Our ref: HA/2014/116369/01-L01
Your ref: R/238/14/PL
Date: 26 November 2014

**1 NO. DWELLING & ASSOCIATED LANDSCAPES WORKS. RESUBMISSION
LAND WEST OF PADDOCK PLACE (LITTLE FOSTERS)
TAMARISK WAY RUSTINGTON BN16 2TE**

GROUND FLOOR
PROPOSED
1:100 @ A3
4112-5 AB

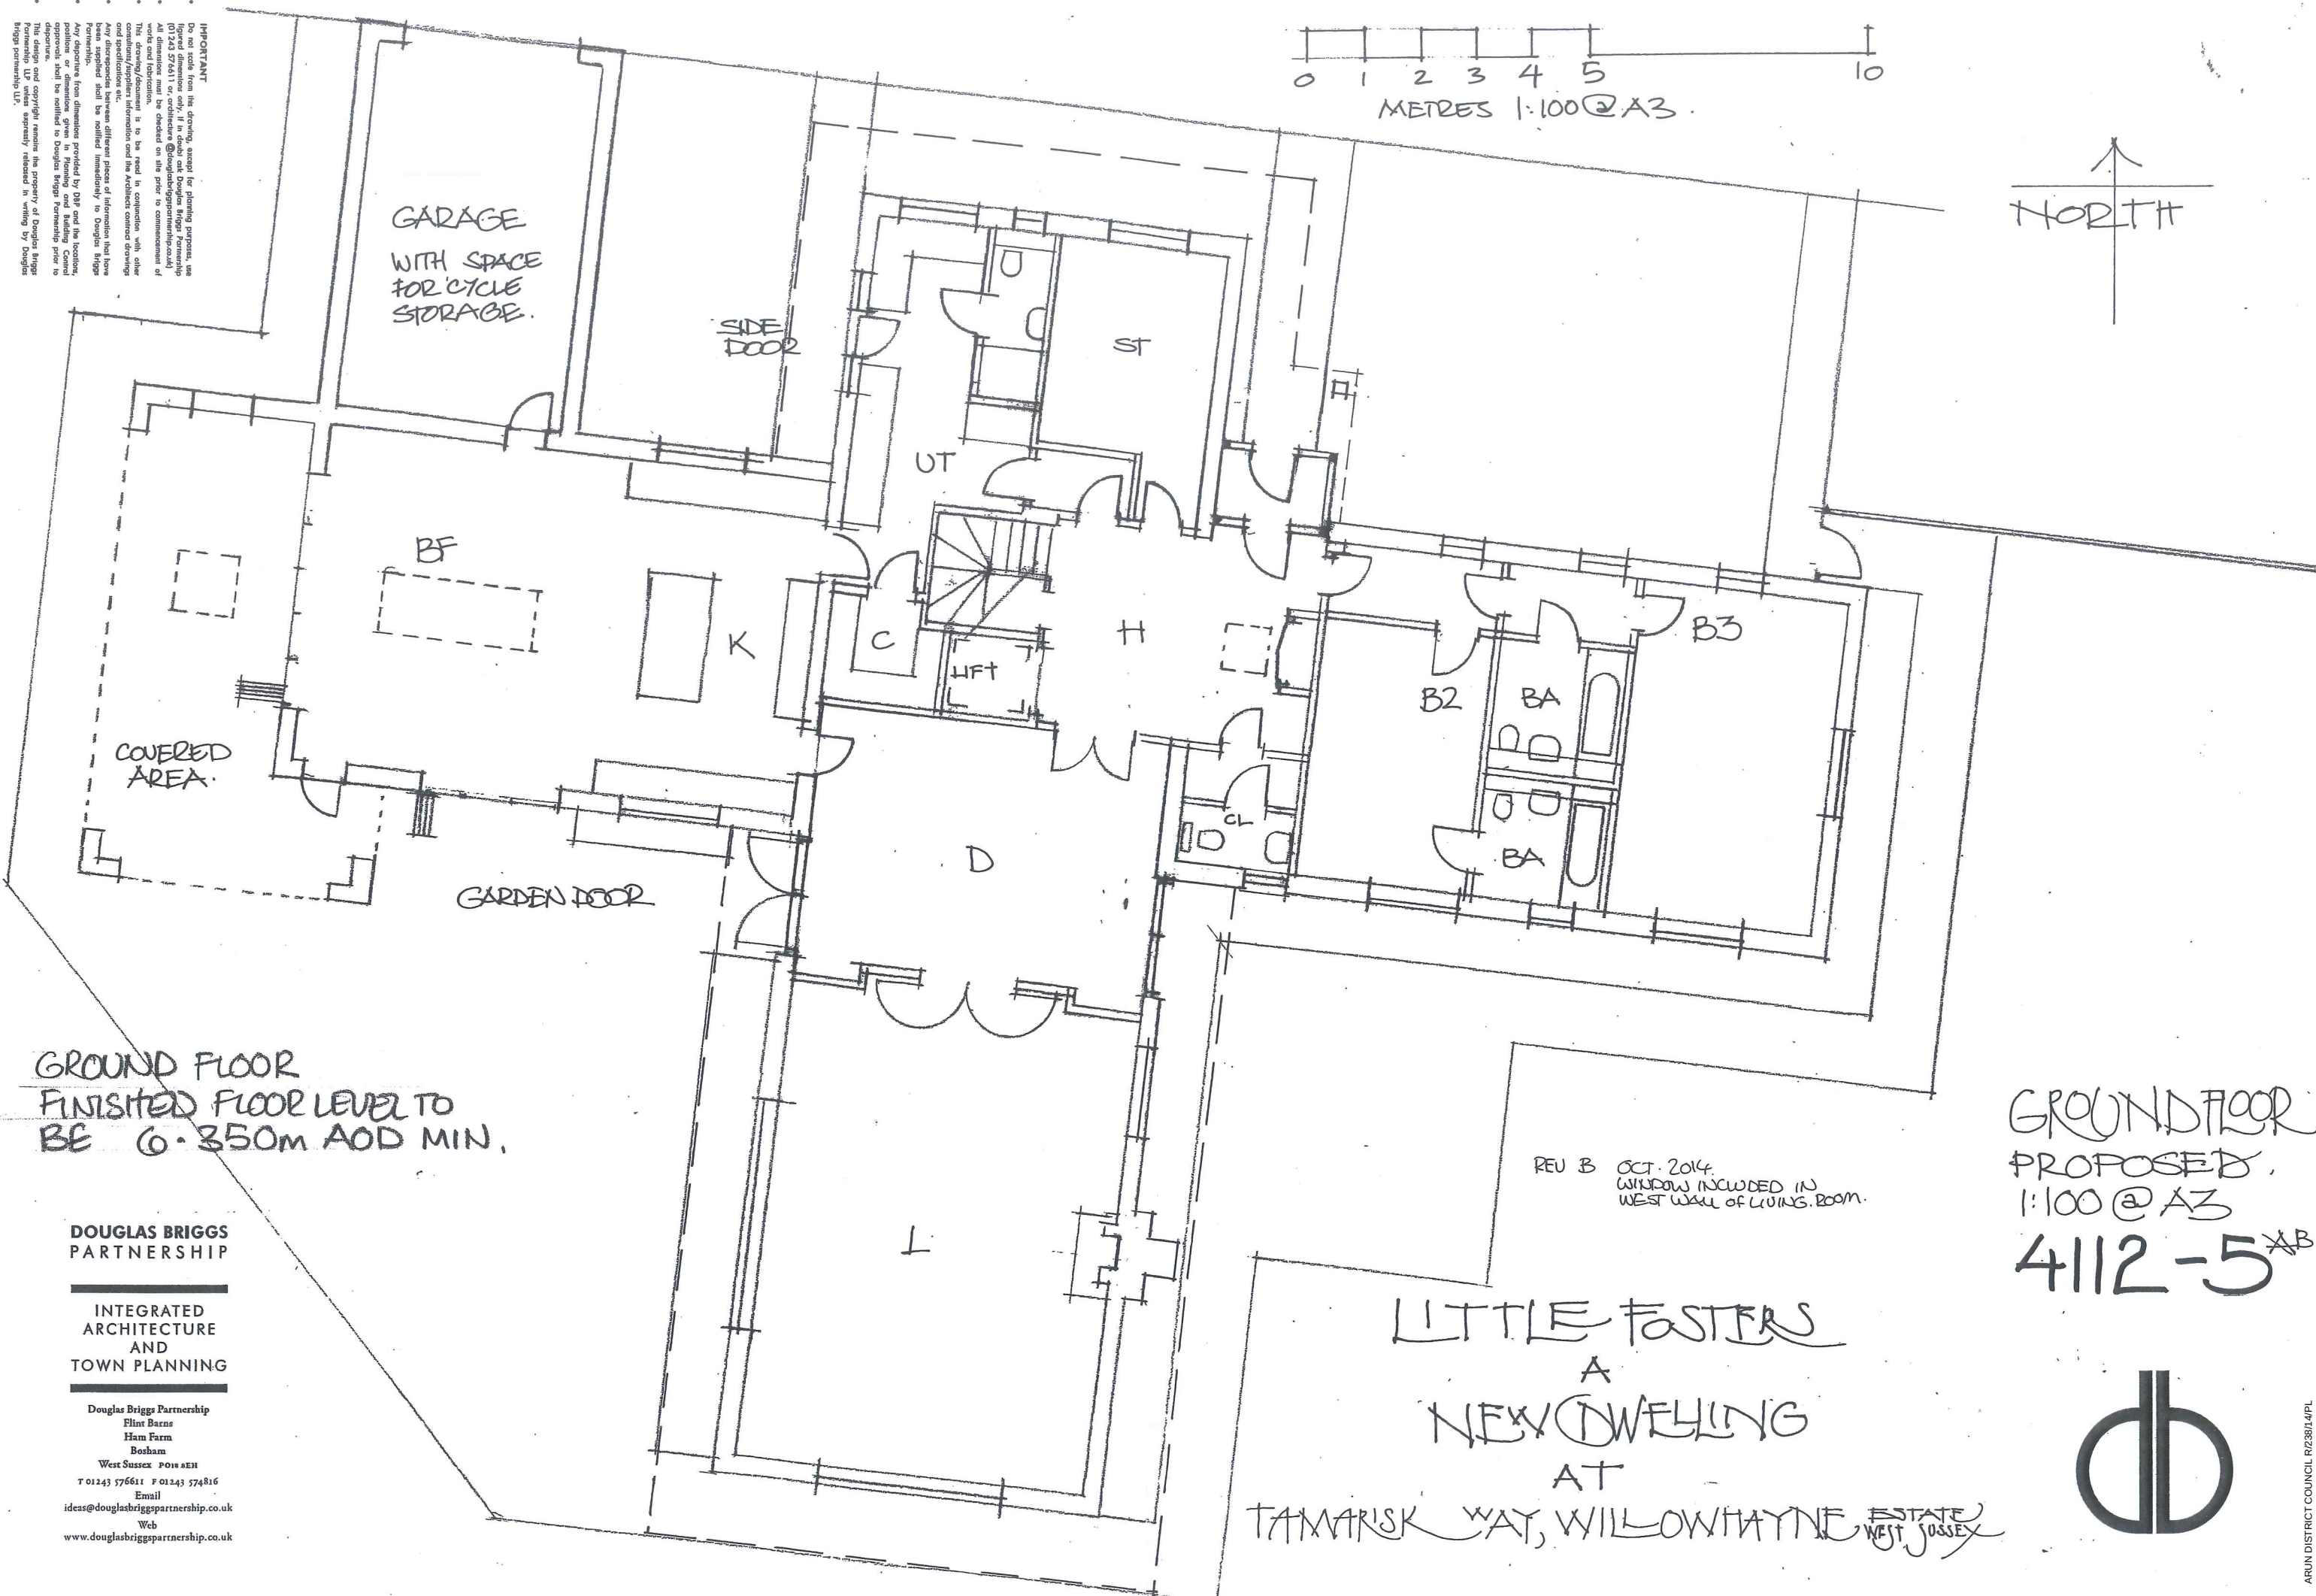
The development permitted by this planning permission shall only be carried out in accordance with the approved Flood Risk Assessment (FRA) [Oct 2014] and the following mitigation measures detailed within the FRA:

Finished floor levels are set no lower than 6.35 m above Ordnance Datum (AOD).
